From: Kathryn Griffiths <[REDACTED]>
Sent: 20 February 2019 15:44
To: Simon Davis
Cc: Zoe Knott
Subject: RE: Burndell Road - Y/98/18/RES

Thank you for your comments of 12th February which we have considered and respond to below.

- Street lighting (SSE235781 Letter of approval)
- Layout (18-1065-005 C Site Plan Planning Layout)
- Affordable housing tenure mix layout (18-1065-005 C Site Plan Planning Layout)
- Soft Landscape Proposals (BOV22172 – 11E sheets 1-5)
- Hard Landscape Proposals (BOV22172 – 12E sheets 1-5)

BOVIS HOMES
scheme: Land off Burndell Road
Yapton
client: Bovis Homes
drawing: Hard Landscape Proposals
date: Nov. 2018
scale: 1:200@A1
drawing no: BOV22172 12E sheet 3
drawn: AE checked: DKM

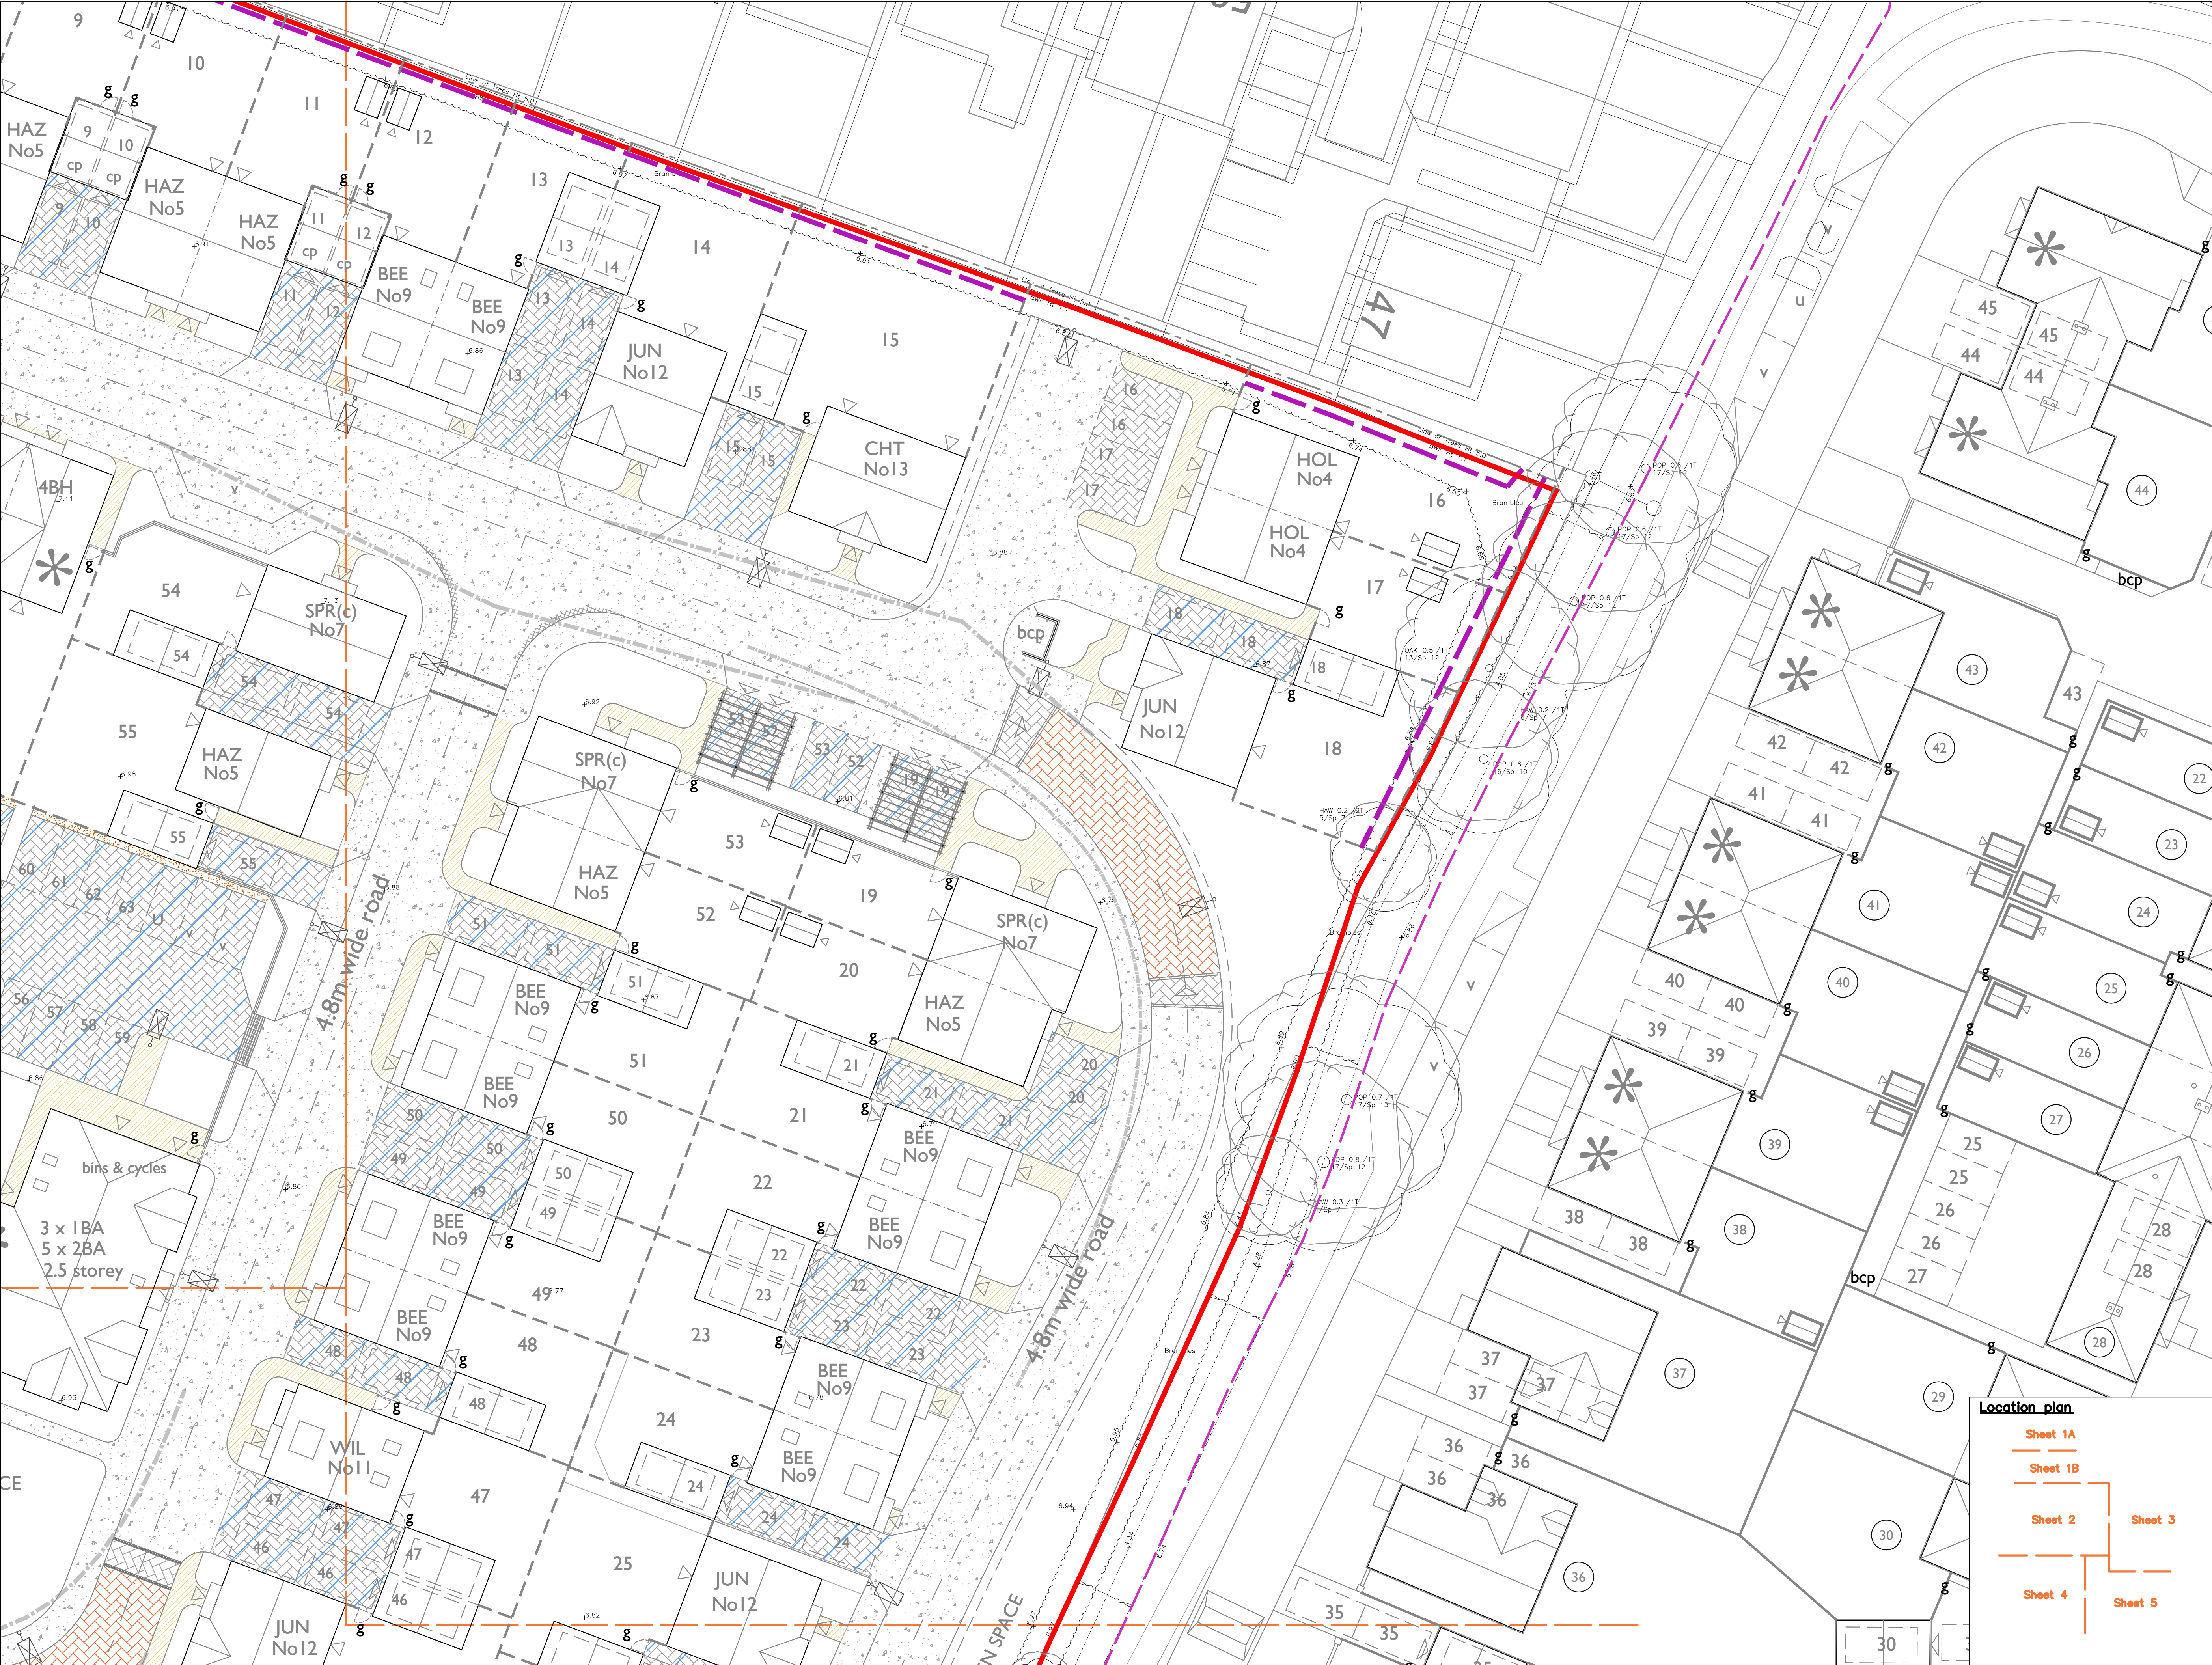
- (4) Concern was raised as to the lack of viewpoints within certain roads in the layout. For example, when driving east down the road between the LAP and plots 37-39, the end view is of a car park plus the rear boundary to 26/27. It was considered better design if the end focal point is of a house frontage. There are other similar examples of this within the layout; and

The viewpoint comments have been taken on board and changes have been made to the layout (see attached). Parking spaces for unit 45 have been relocated to create space for tree planting that will provide green views to this part of the development.

BOVIS HOMES
scheme: Land off Burndell Road Yapton
client: Bovis Homes
drawing: Hard Landscape Proposals
date: Nov. 2018
scale: 1:200@A1
drawing no: BOV22172 12E sheet 4
drawn: AE checked: DKM

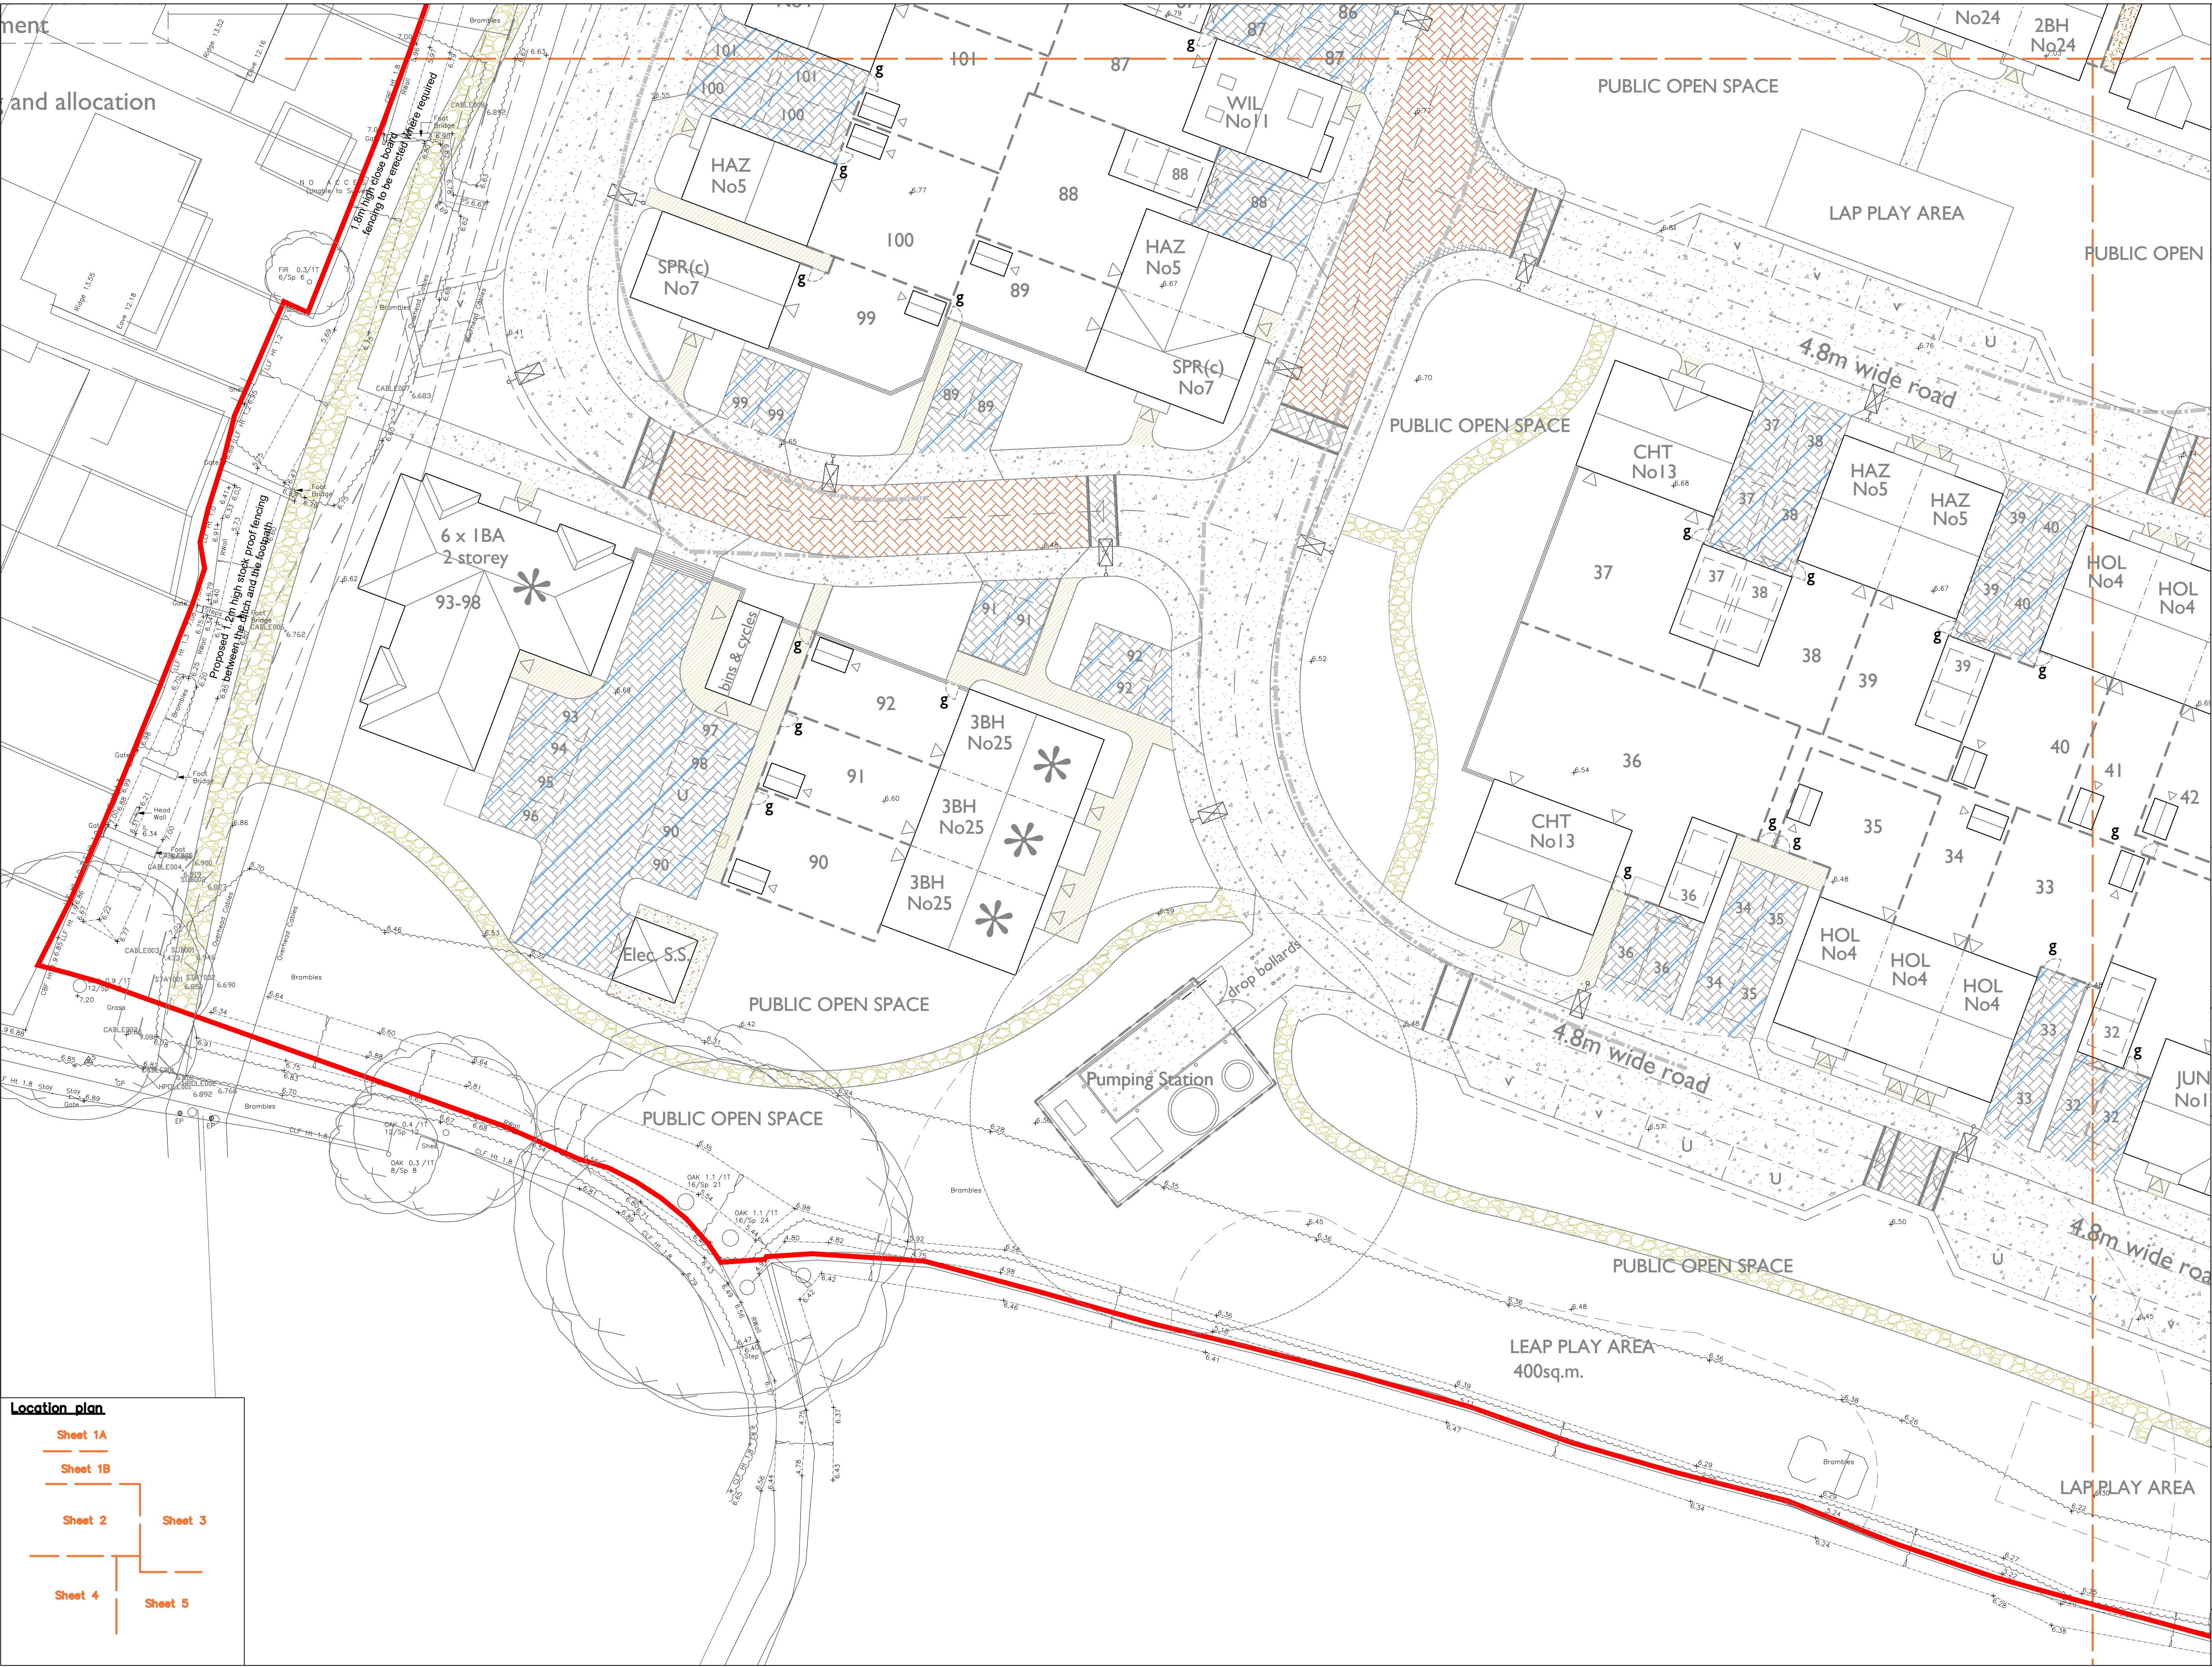
- (5) As you are aware concerns remain re the relationship of existing trees to the attenuation pond (I await Tree Officer comments on this).

The landscape plans have been updated to accord with the latest layout plan and drainage comments received on 2nd and 4th January 2019. Soft landscape drawing (BOV22172 11 sheet 4) shows that trees located immediately south of the attenuation pond and two *Alnus Glutinosa* trees to the south of the electricity substation have been removed to provide sufficient easement (5m buffer) from the attenuation features and watercourses. Soft landscape drawing (BOV22172 11 sheet 4) also shows trees alongside the pump station to have been removed/relocated and hedges have been adjusted in line with the sight lines.

The relationship between the existing trees to the attenuation ponds has been reviewed and the trees are now away from the bank of the watercourse as shown on the revised landscaping plans.
